From: Laura Gibbons
Sent: 29 October 2018 09:12
To: Planning.Responses
Subject: RE: Planning Consultation on FG/171/18/DOC

Engineers Comments Regarding Condition 3- Drainage

APPLICATION NO: FG/171/18/DOC

Site Address: Garage Premises Littlehampton Road Ferring BN12 6PB

FIGURE 2: INVESTIGATION LOCATION PLAN

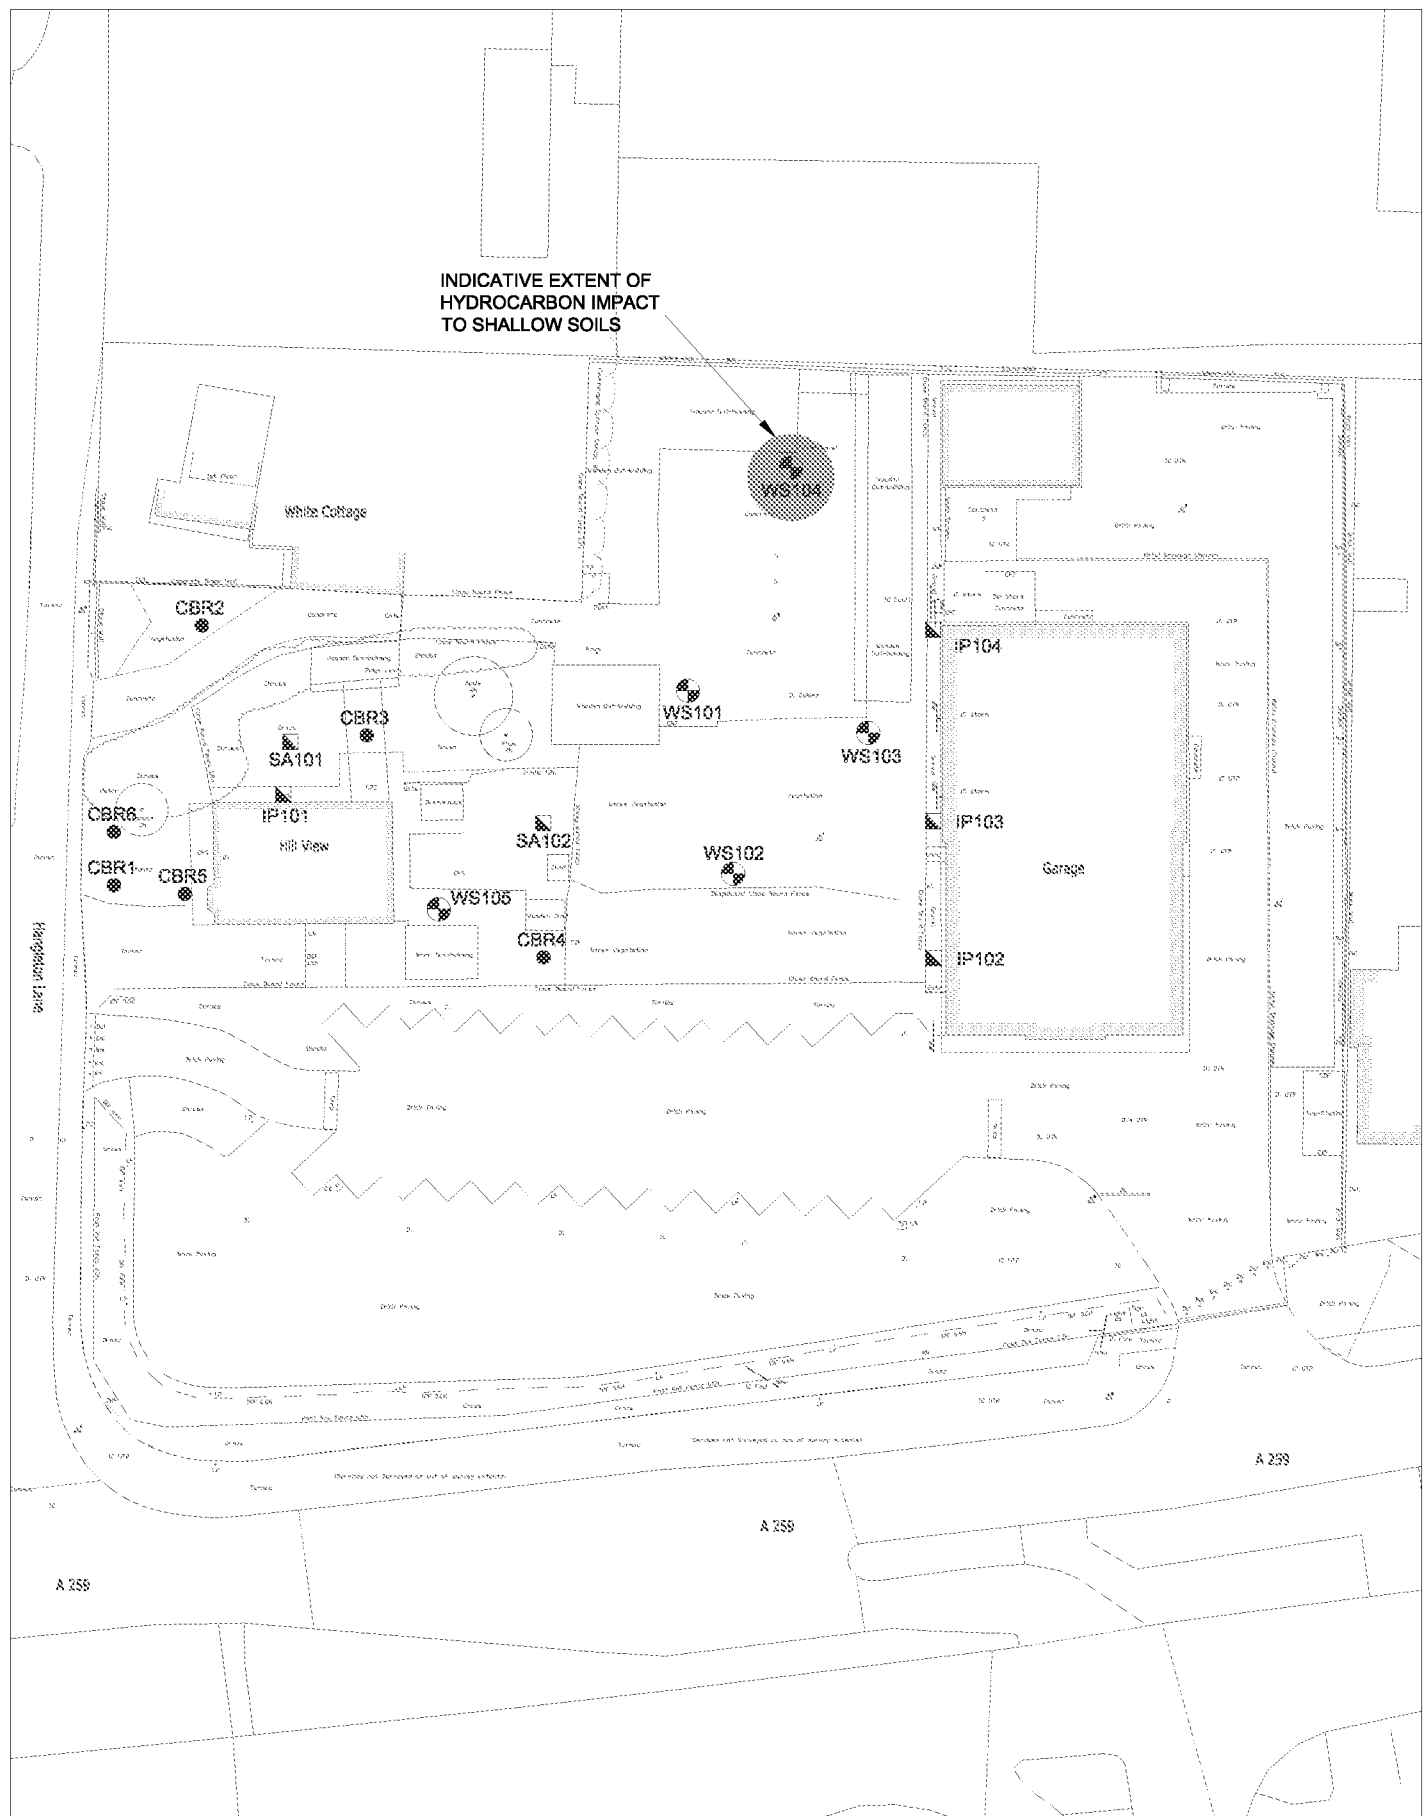
- No winter groundwater monitoring data has been supplied.
- It is also not evident when the infiltration testing was completed. This must be completed in the winter.
- Furthermore, the surface water design is inadequate with the 1 in 100 year plus climate change event not stored below ground. The drainage must capacity in the system to contain below ground level the 1 in 100 year event plus 40% on stored volumes.
- Exceedance flow rates need to be demonstrated.
- Construction detail drawings supplied.
